Response to Planning application from Hertfordshire County Council (T and CP GDP Order 2015)

District ref: 6/2020/1990/PN11
HCC ref: WH/3143/2020
HCC received: 25 August 2020
Area manager: Matthew Armstrong
Case officer: Ania Jakacka

EVEREST HOUSE SOPERS ROAD CUFFLEY POTTERS BAR EN6 4SG

Prior notification for the change of use from office (B1A use class) to residential (C3 use class) to create no. 32 residential units.

Drawing title
Proposed Ground
and Lower Ground floor Plan

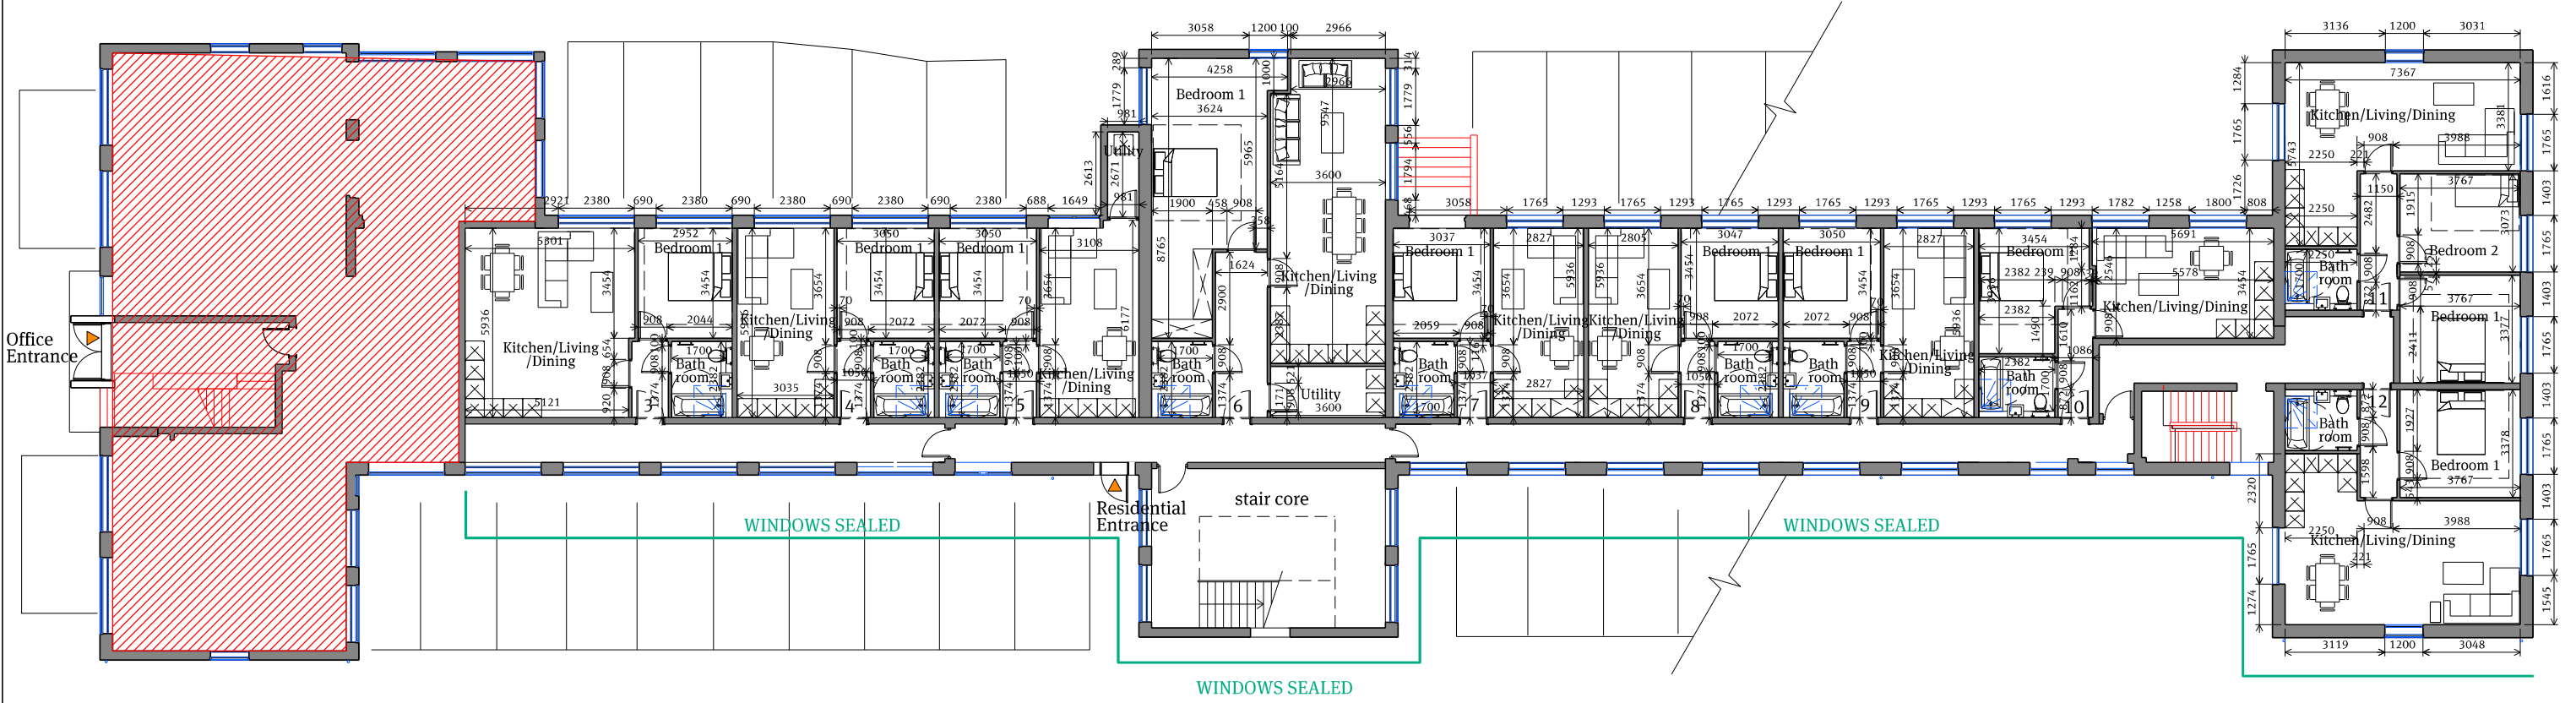
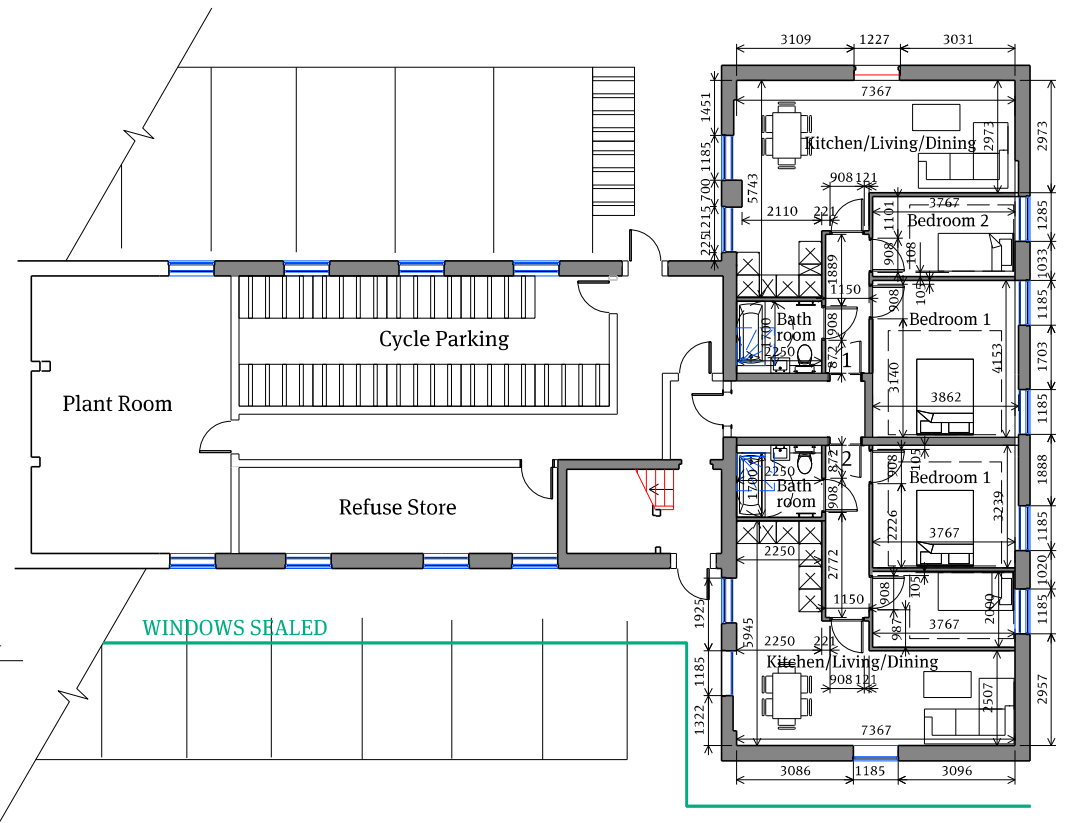
The subject site is located to the eastern side of Sopers Road that is designated as a local distributor road and is subject to a 30mph speed limit along this section of road. Since no detailed site layout plans were submitted to show the access to/from Sopers Road and internal arrangements it is unclear what access provisions would be for the new use and how access will be shared between the residential and the office use remaining on site.

The site will require access by domestic waste collection vehicles, yet there is no information provided as part of this submission to explain how refuse and servicing will be undertaken. It should be noted that the are distance limits for refuse vehicle operatives to walk from the truck to the collection point and trucks should not reverse more than 12m. Likewise, the applicant should demonstrate that refuse areas are within acceptable walking distance for residents of the development. Given the number of units and an increase in online shopping, consideration should be given now to accommodate, within the parking layout, bays for delivery vehicles like food deliveries.

In terms of on-site parking, the proposed development would include the provision of 43 car parking spaces (according to the Cover Letter). WHDC's parking standards are set out within the Council's Supplementary Planning Guidance (SPG) and zonal restraint-based approach is applied. The site falls within Zone 4. Although the provision appears to comply with the adopted standards, parking spaces have not been shown on the plans and again it is unclear how these will be accessed or shared with the office use nearby.
